Re: Construction Seminars - 4927 Prospect Ave NE; Bldg Permit # 201691091
Request for Certificate of Occupancy- Transportation Development
Architect's Stamp dated 08-04-16 (H17D112)
Certification dated 10-13-16

Project Title: Construction Seminars

Re: Construction Seminars Renovations
7915 Prospect Ave NE
Traffic Circulation Layout
Architect's Stamp 08-04-16 (H17D104)

Re: Construction Seminars Renovations
4915 Prospect Ave NE
Traffic Circulation Layout
Architect's Stamp 07-20-16 (H17D104)
12

**A1 PROPOSED SITE PLAN**  
SCALE: 1" = 20'-0"

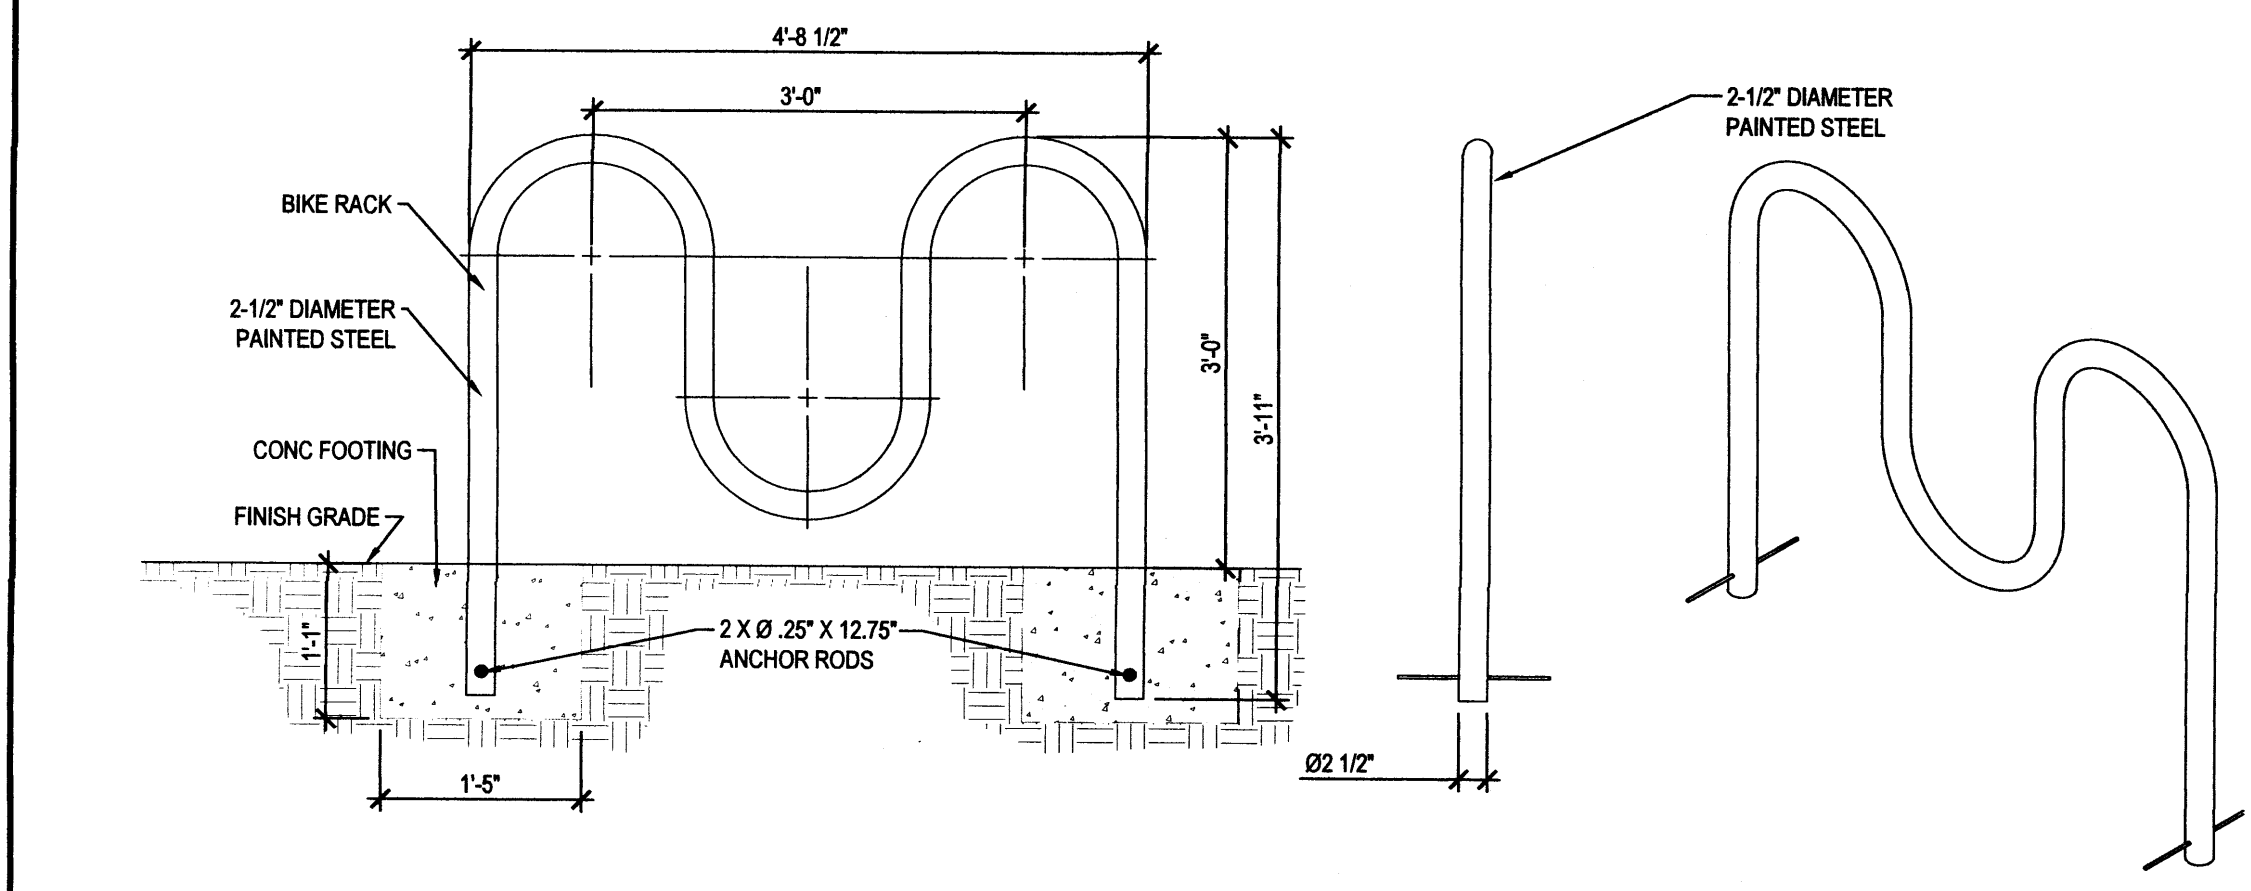
1. The 6' pedestrian access aisle called out on the approved TCL must be completed per plan.
2. The ADA access aisle route to the warehouse is not in compliance with ADA guidelines for slopes requirements. One HC parking space and access aisle will need to be relocated to allow proper ADA access to the building.

PROPOSED SITE PLAN - TRAFFIC CIRCULATION LAYOUT SUBMISSION

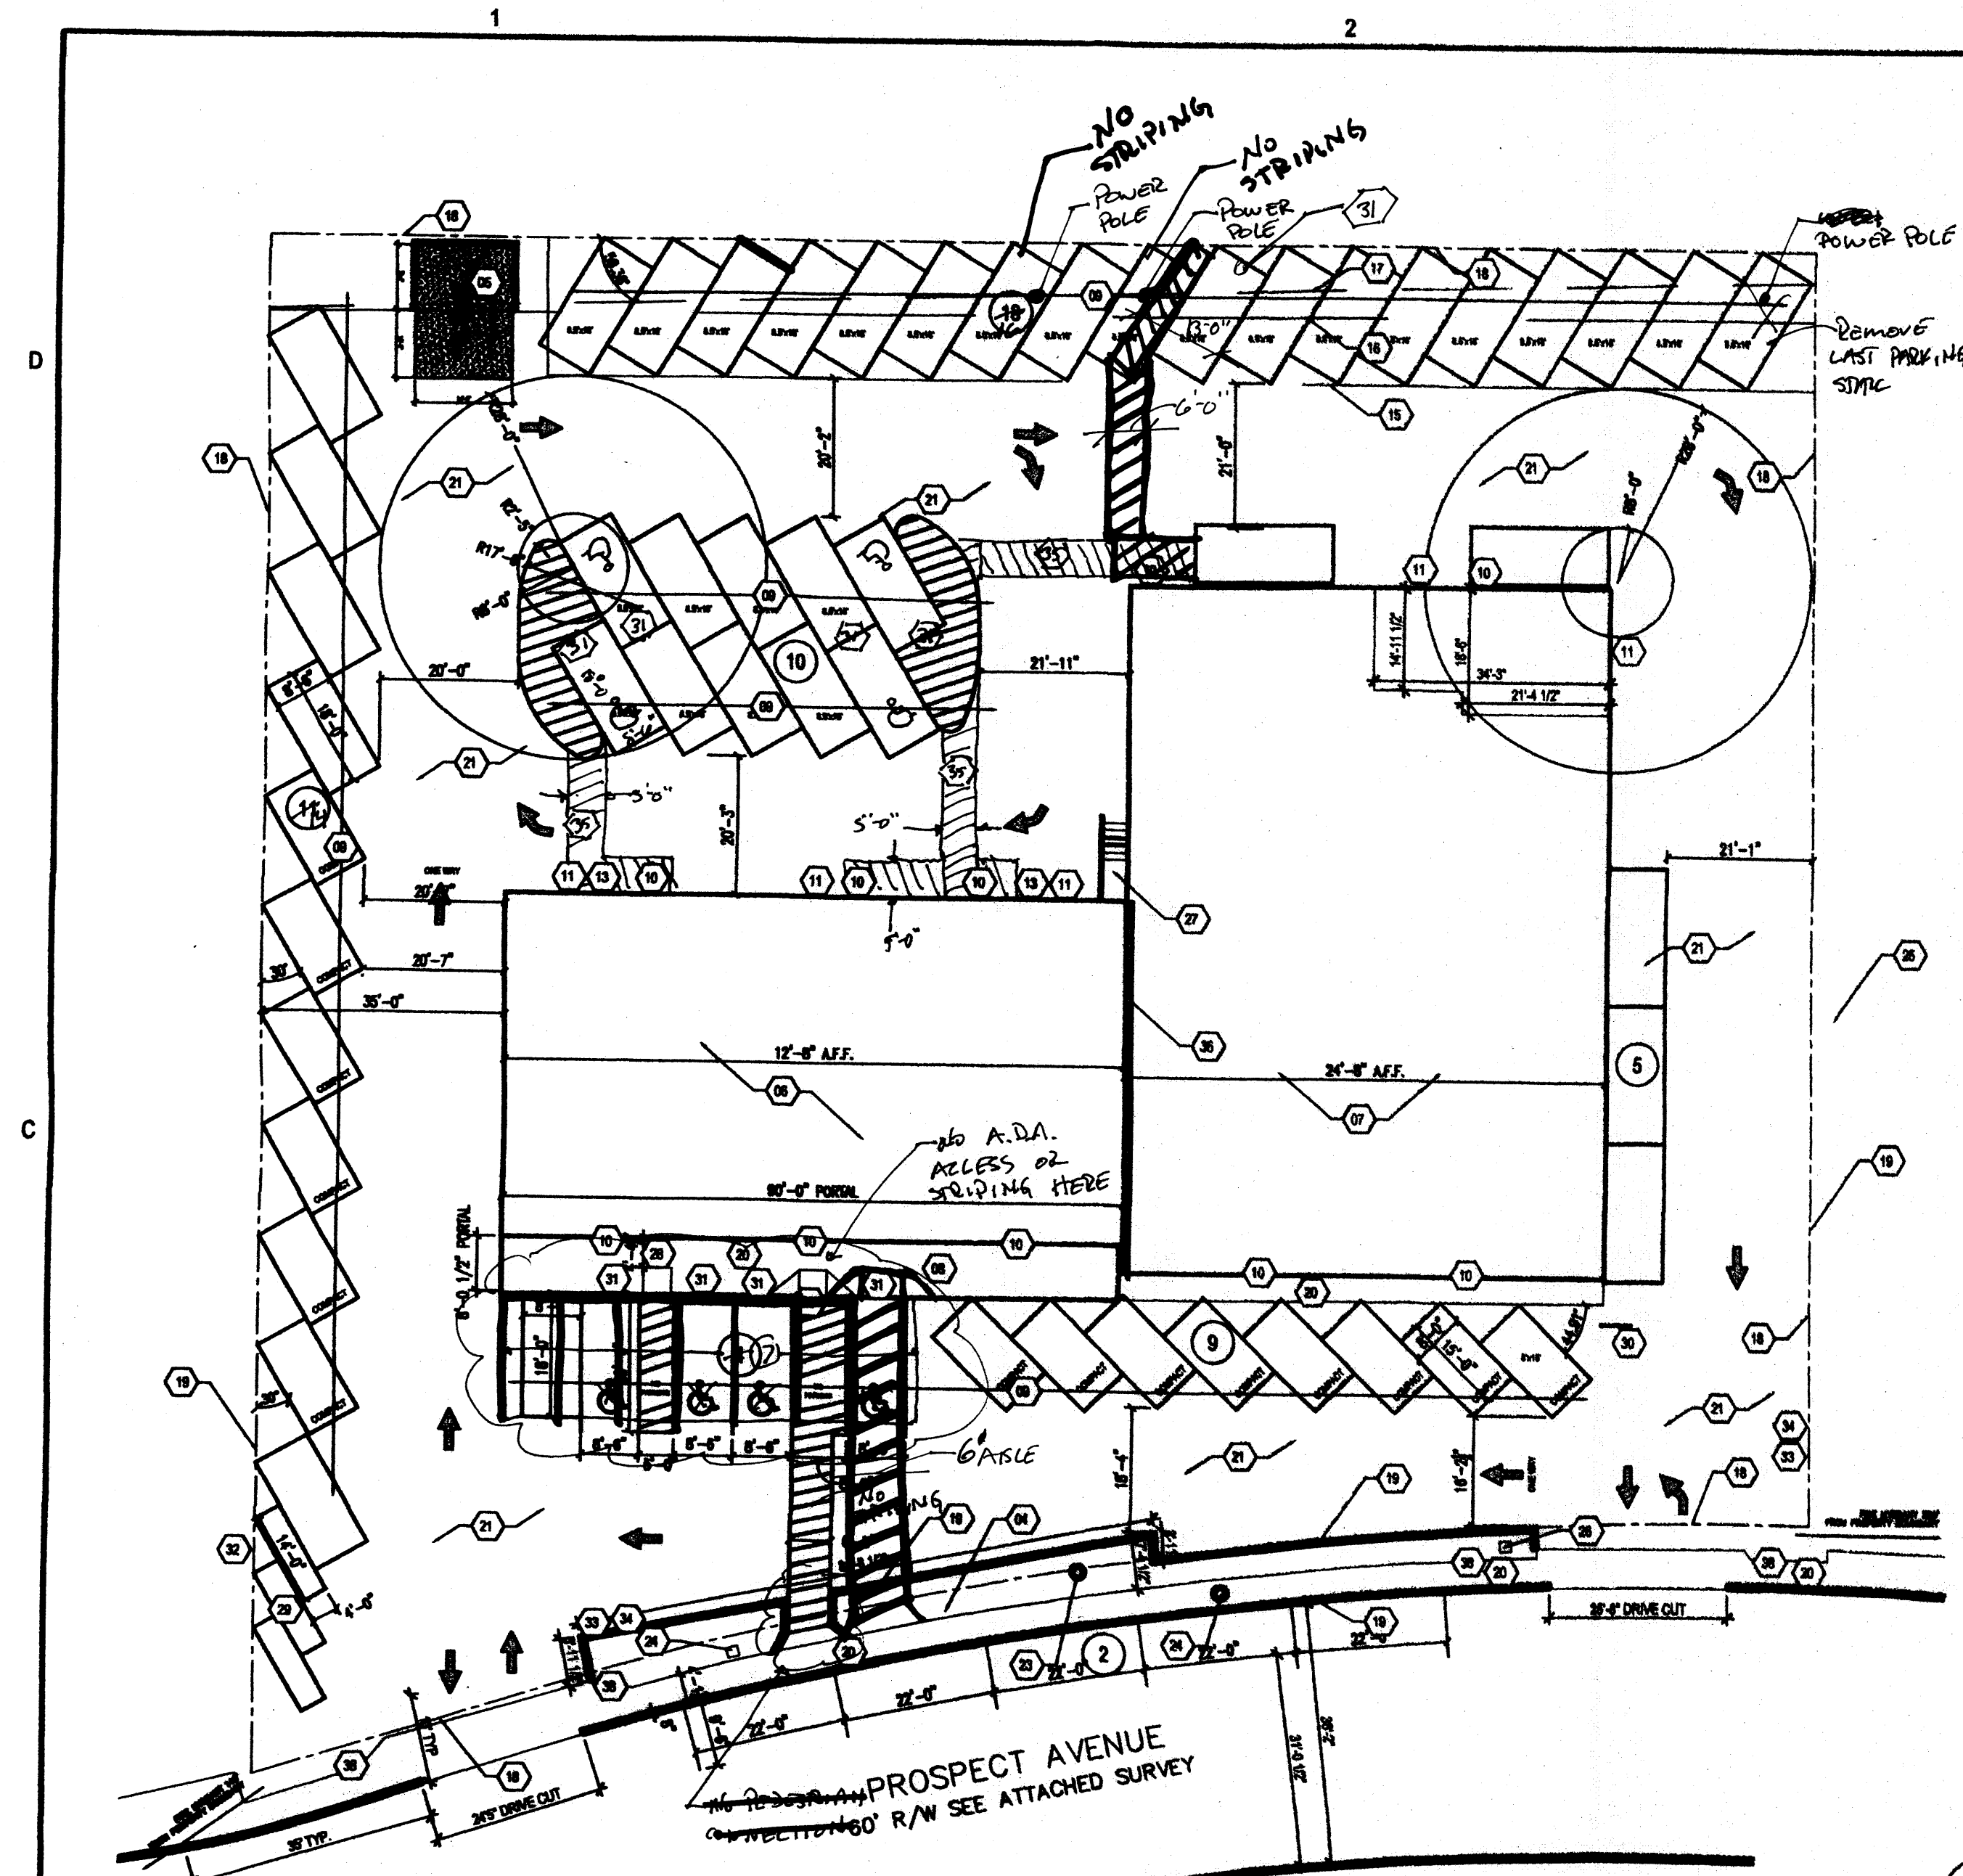
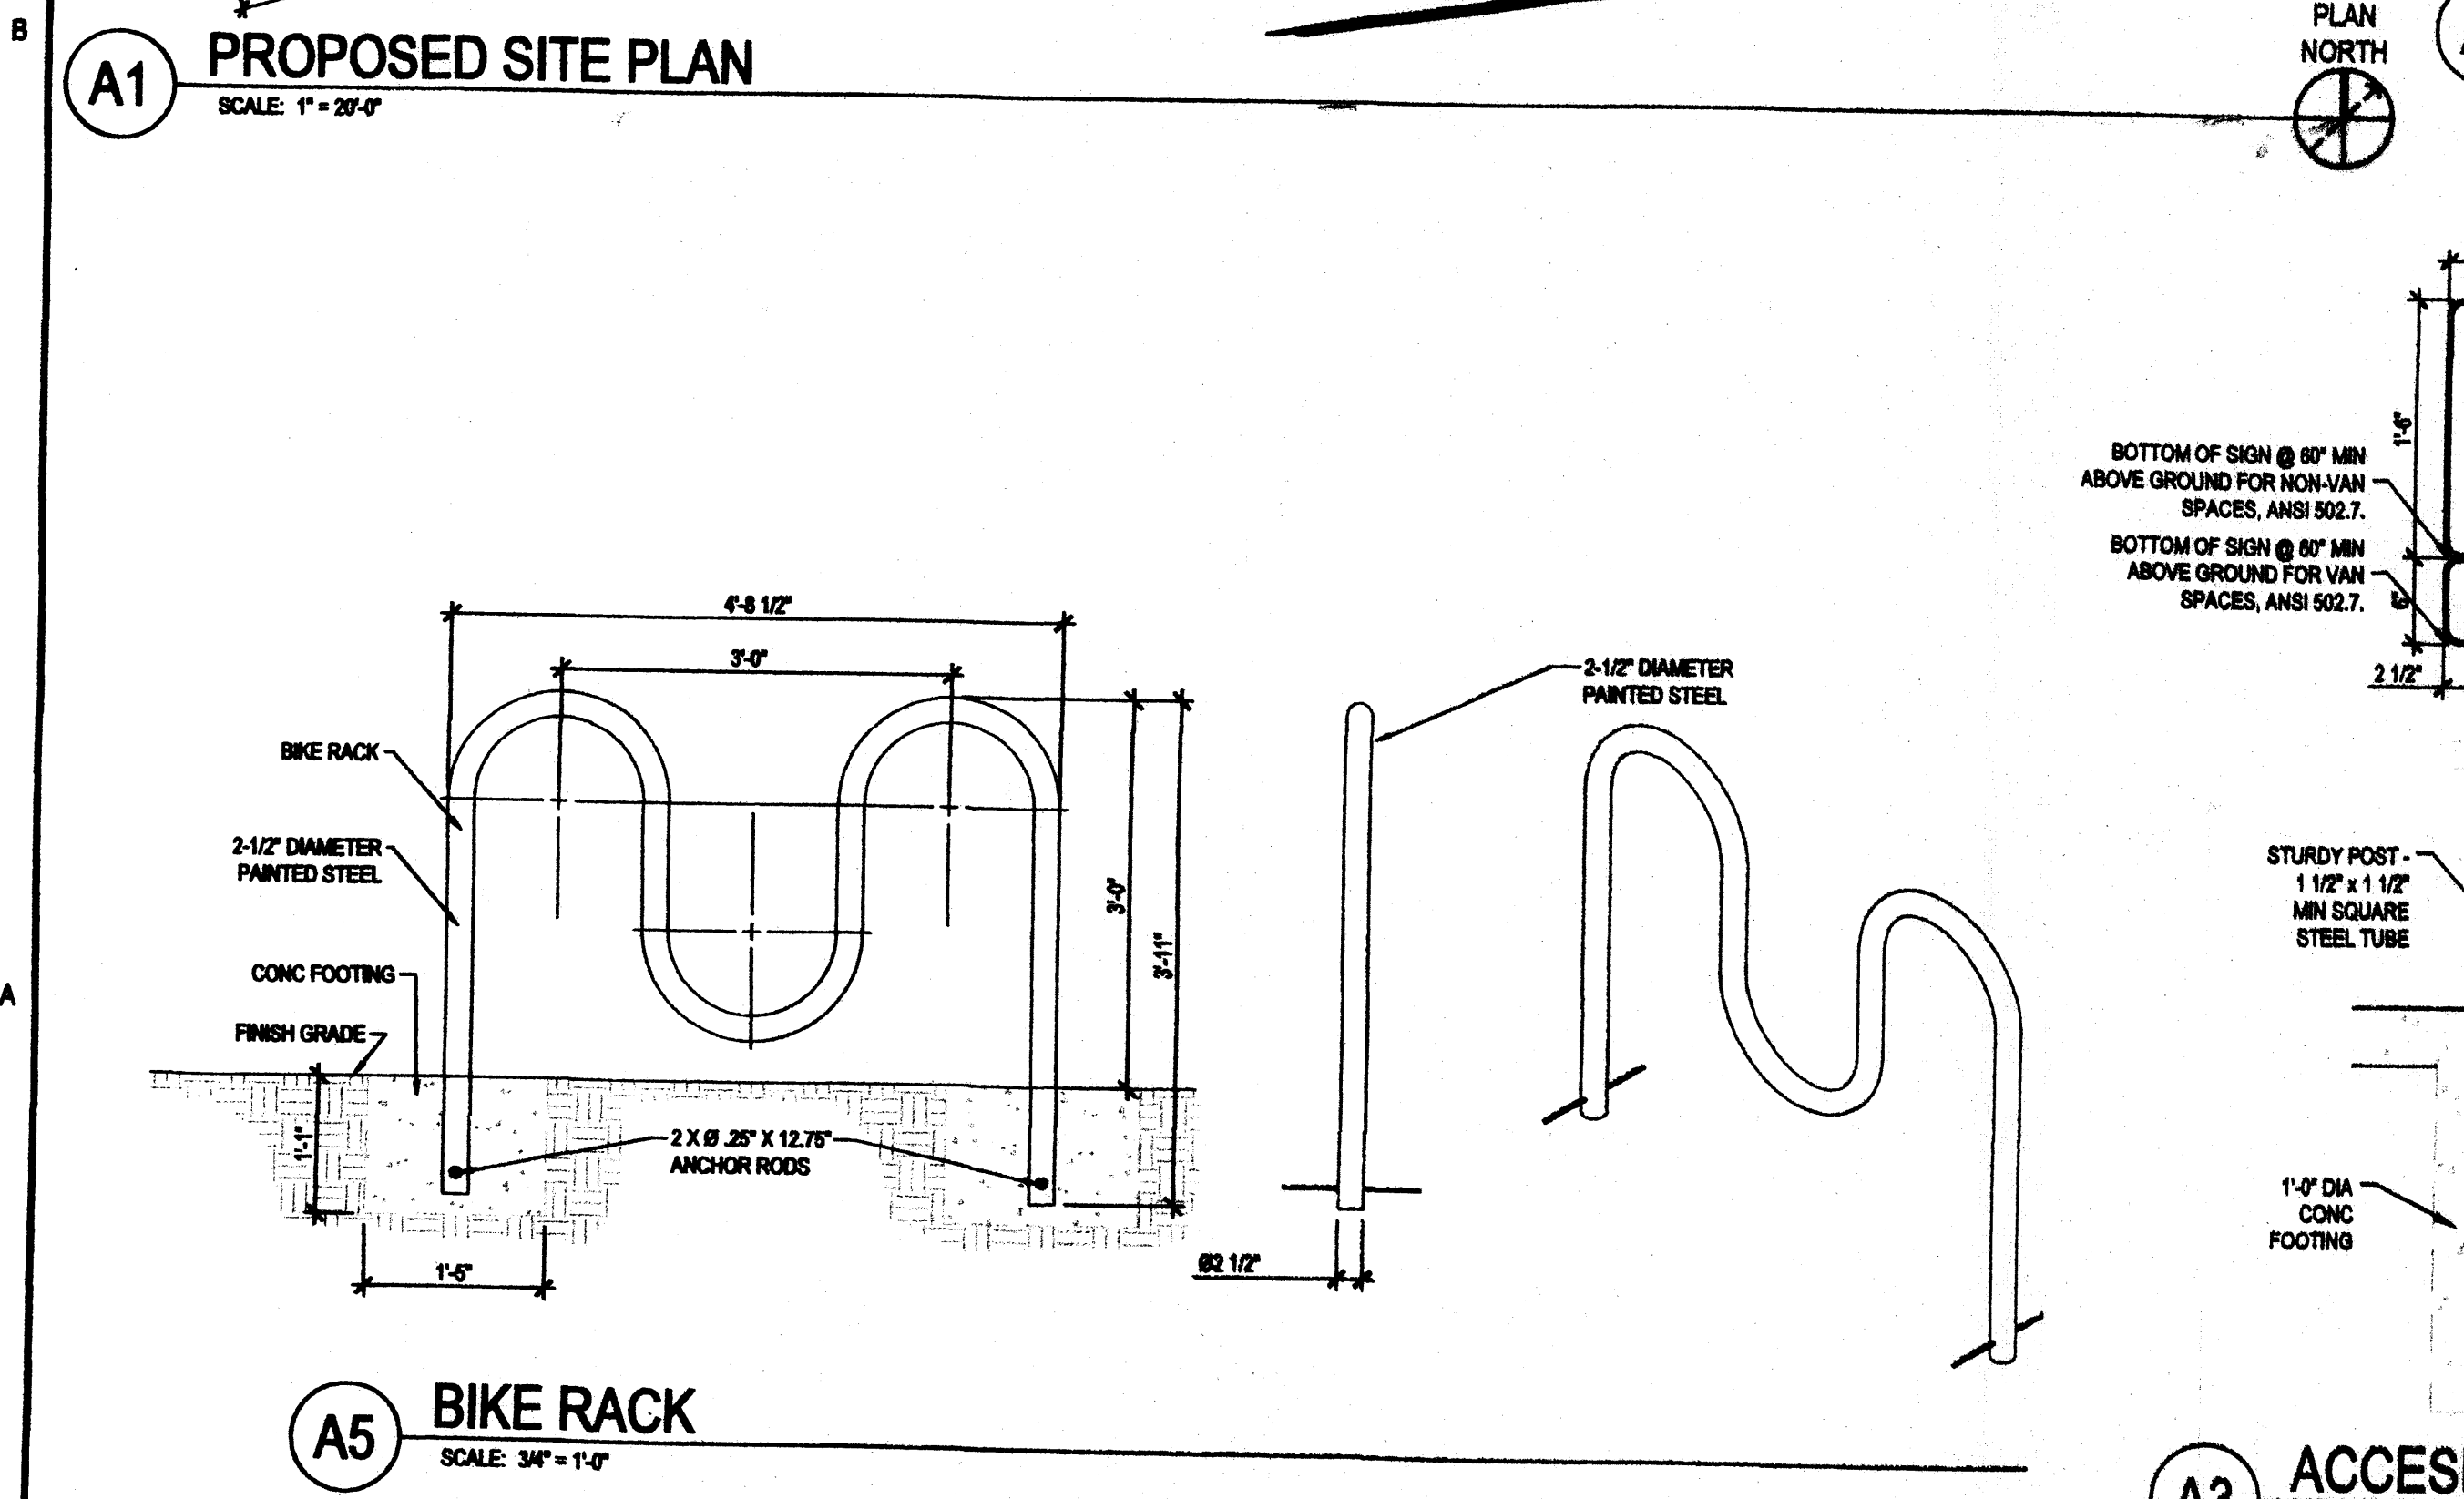
- ✓ 1. Please show a vicinity map showing the location of the development in relation to streets and well known landmarks.
- ✓ 2. Identify the right of way width, medians, curb cuts, and street widths on Prospect Ave NE.

- ✓ 3. The 6 ft. wide ADA accessible pedestrian pathway required from the public sidewalk to the building entrances must be clear of any curb lines. Please clearly show this pathway and provide details.

- ✓ 4. Provide a detail of all ADA accessible ramps onsite.
- ✓ 5. Provide dimensions of motorcycle parking. (Zoning Code, 14-16-31, C.)
- ✓ 6. One-way vehicular paths require pavement directional signage and a posted "Do Not Enter" sign at the point of egress. Please show detail and location of posted signs.

- ✓ 7. Please provide a sight distance exhibit (see the *Development Process Manual, Chapter 23, Section 6, Part B.12 Visibility for Driveways*).
- ✓ 8. Please add the following note to the clear sight triangle: "Landscaping and signage will not interfere with clear sight requirements. Therefore, signs, walls, trees, and shrubbery between 3 and 8 feet tall (as measured from the gutter pan) will not be acceptable in this area."

- ✓ 9. Please specify the City Standard Drawing Number when applicable.
- ✓ 10. Add keynote 11 to all overhead garage doors.
- ✓ 11. Provide conformation from zoning the amount of parking required and provided is correct. Does not need AA approval per previous site plan

- ✓ 12. Clarify the limits of the portal that covers the front walkway.

- ✓ 13. Show the existing property lines.
14. Please add a note on the plan stating "All improvements located in the Right of Way must be included on the work order."

- ✓ 15. Show the 3 curbside parking spaces called out on the parking total requirements. If On-street parking credit is required please follow item to request On-Street parking.

- ✓ 16. On-Street parking Allowance to fulfill zoning's parking requirement must be requested and approved by the Traffic Engineer, Racquel Michel prior to TCL approval. The application requires at least 30 working days. On-street parking allowances are based on available parking along public right-of-ways fronting the property. The business will only be granted 50% credit for available street parking.

- ✓ 17. Add a note stating "All broken or cracked sidewalk must be replaced with sidewalk and curb & gutter." A build note must be provided referring to the appropriate City Standard drawing.
